Memorandum

Re: Cottonwood Crossing Car Wash Site Plan Comment Responses (PR-2021-005816)

This memo outlines the responses and changes made to the Cottonwood Crossing site plan amendment for development of a car wash at 10084 Coors Boulevard NE based on comments reviewed at the December 15, 2021 DRB meeting.

SITE PLAN

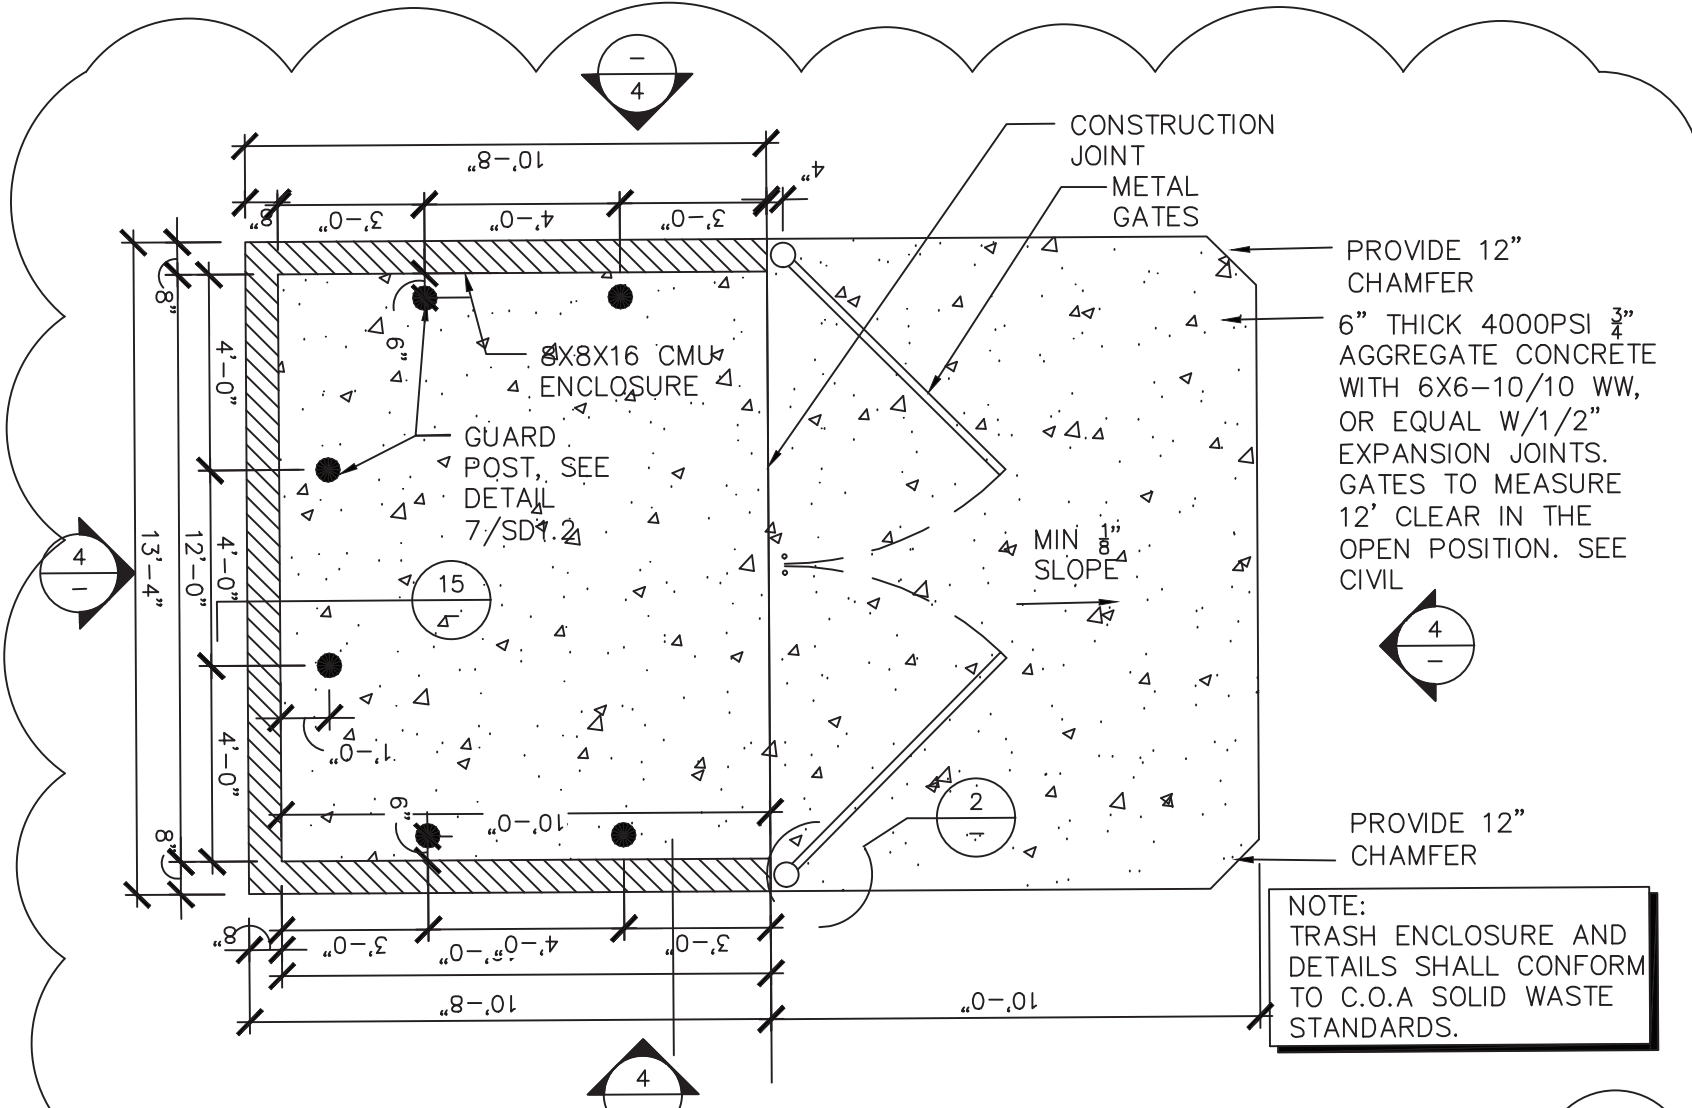
2. Extend striping for east leg at traffic signal to incorporate queuing from the proposed development and to allow for channelization of traffic. (This applies to the area east of the existing raised median.)
The plans have been updated to show this striping extended to the east.

4. Provide clear sight triangle onto private accessway from proposed site. At this location, apply mini clear sight triangle.)
Mini-clear sight triangles have been added to the site plan and landscape plan.

5. List dimensions for all parking aisles and parking spaces, including those that are existing. List all curb radii, and follow DPM criteria based upon design vehicle for the curb radii.
Additional dimensions have been added throughout the plan to call out these elements.

6. For one-way aisles, incorporate "Do Not Enter" signage, "One-way" signage, and directional arrows.
Keynote 30 has been added, calling out a "Do Not Enter" sign at the exit from the vacuum stall area of the site.

12. Label property boundaries. (Include on legend for clarification.)
The property line has been more clearly defined and labeled.

SITE DETAILS

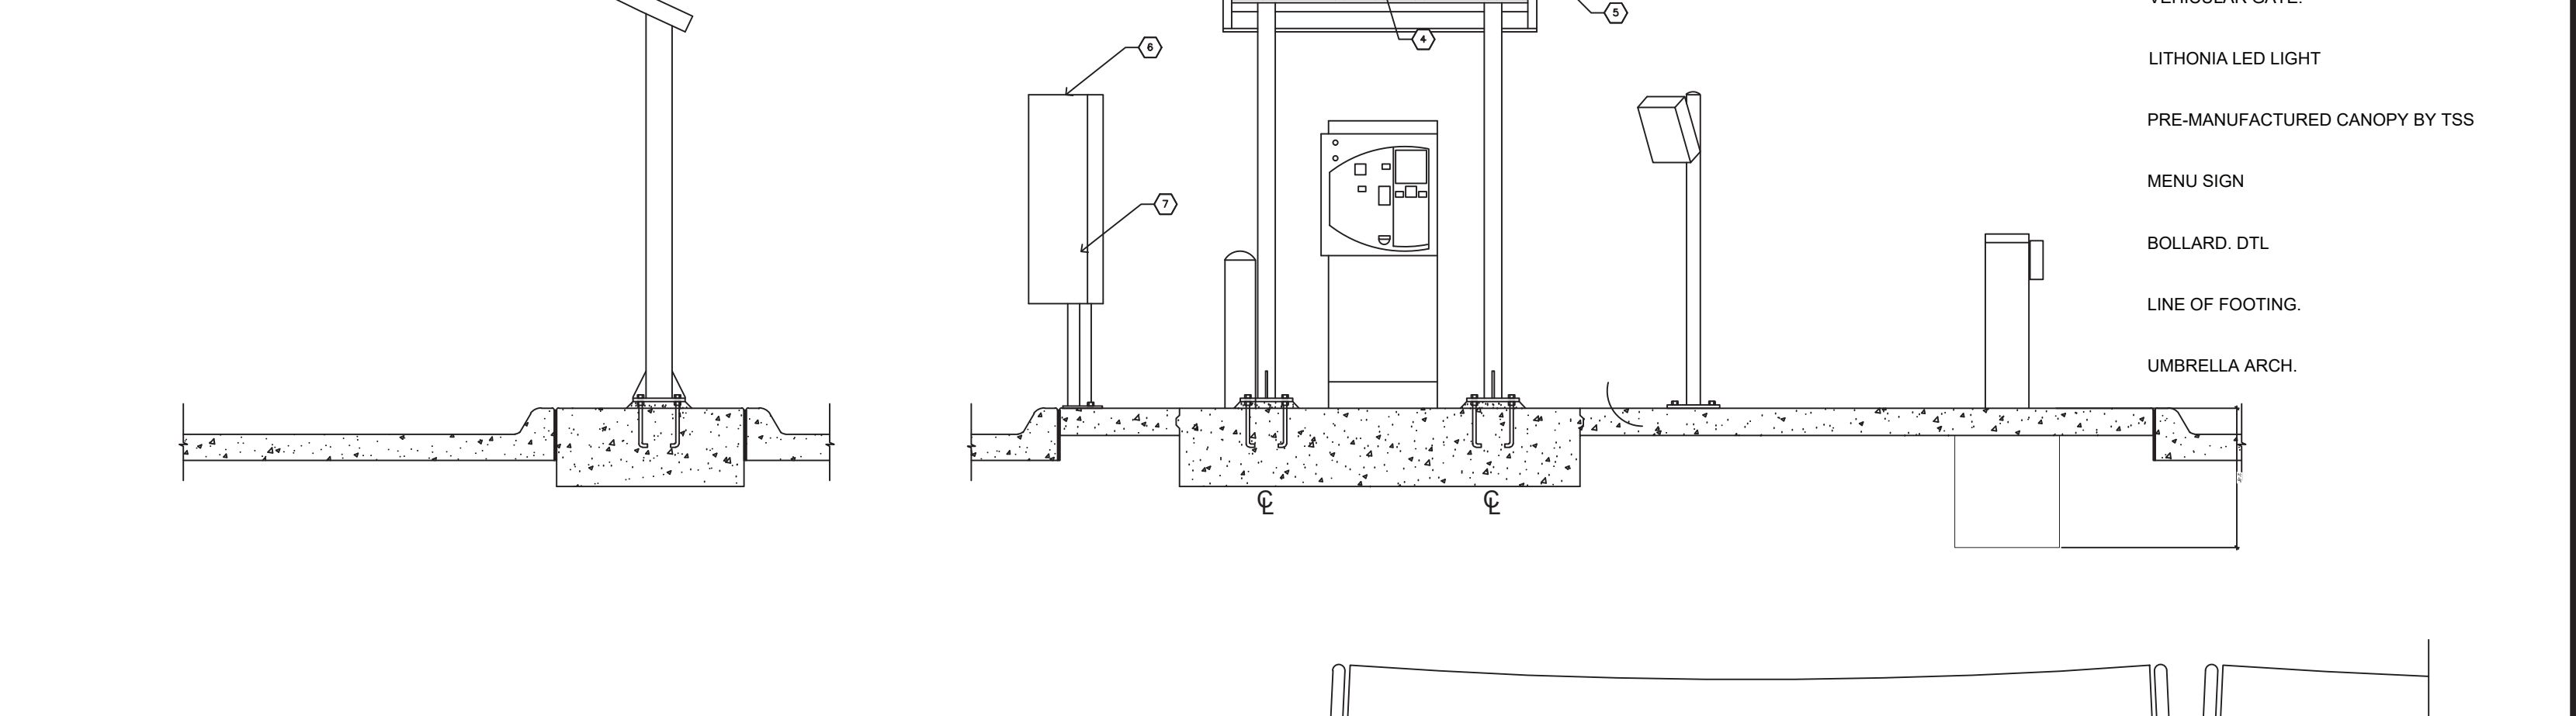
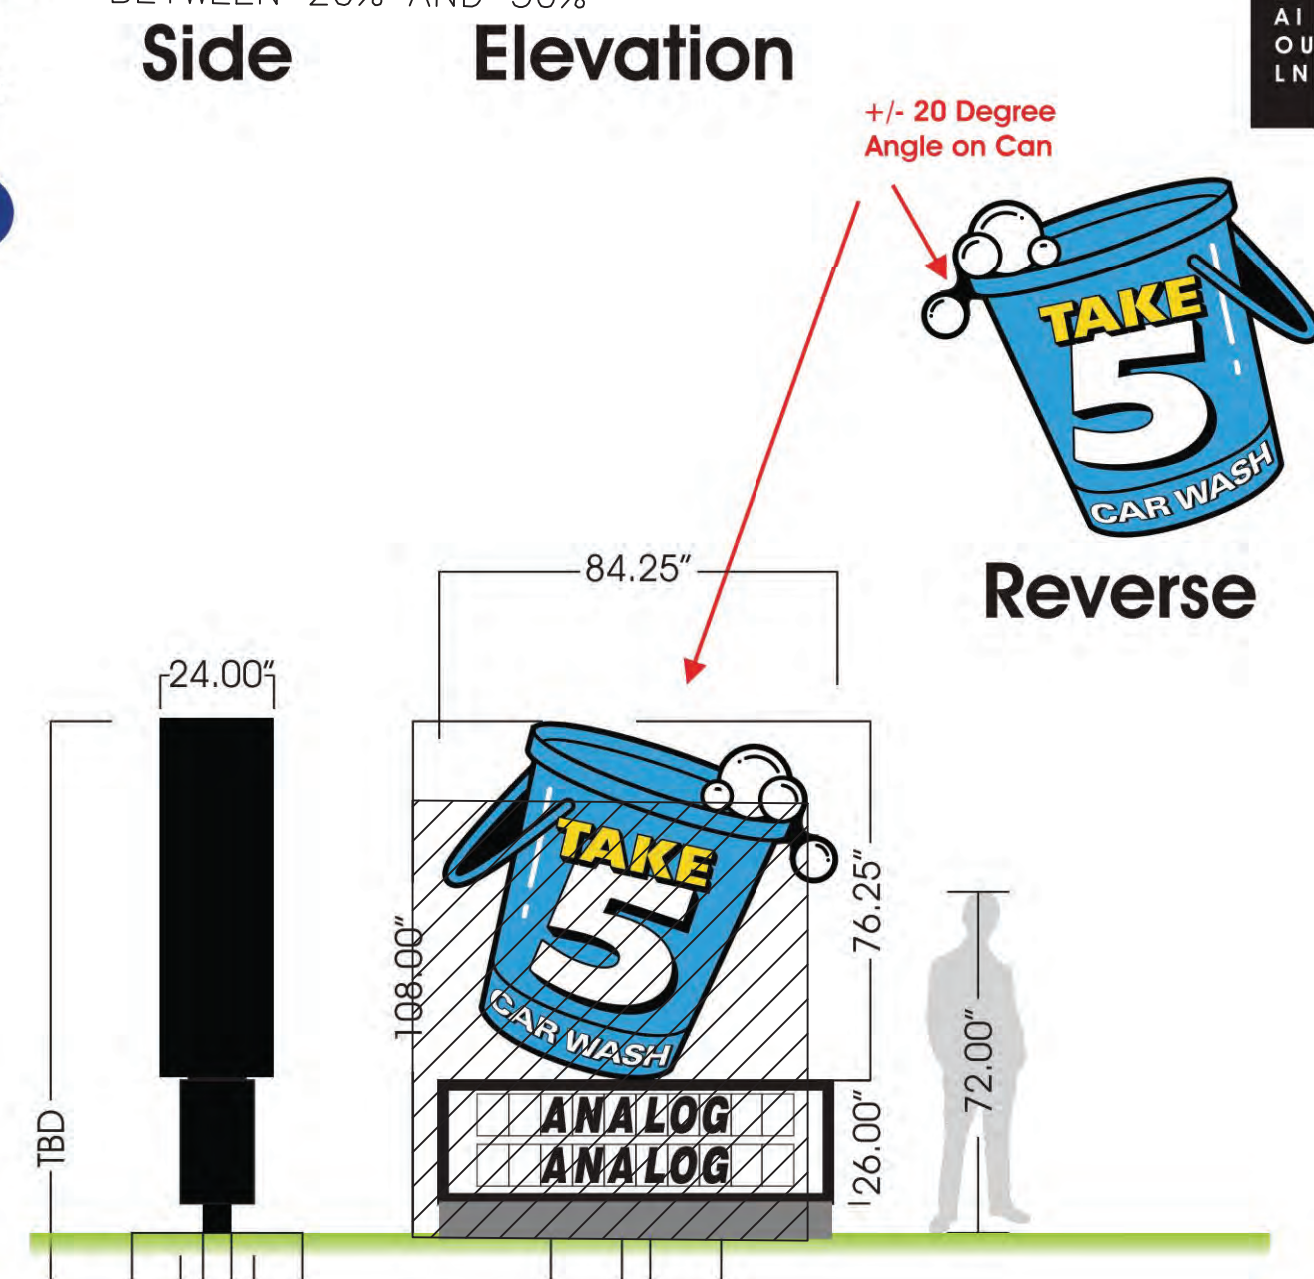
8. Provide curb and sidewalk details on the detail sheet. For the sidewalk detail, show a 2% maximum cross-slope.
Slopes and cross slopes are highlighted on the detail for the pedestrian crossing on Sheet DD1A. Sidewalk and curb details have been added to the grading plan sheet by the civil engineer.
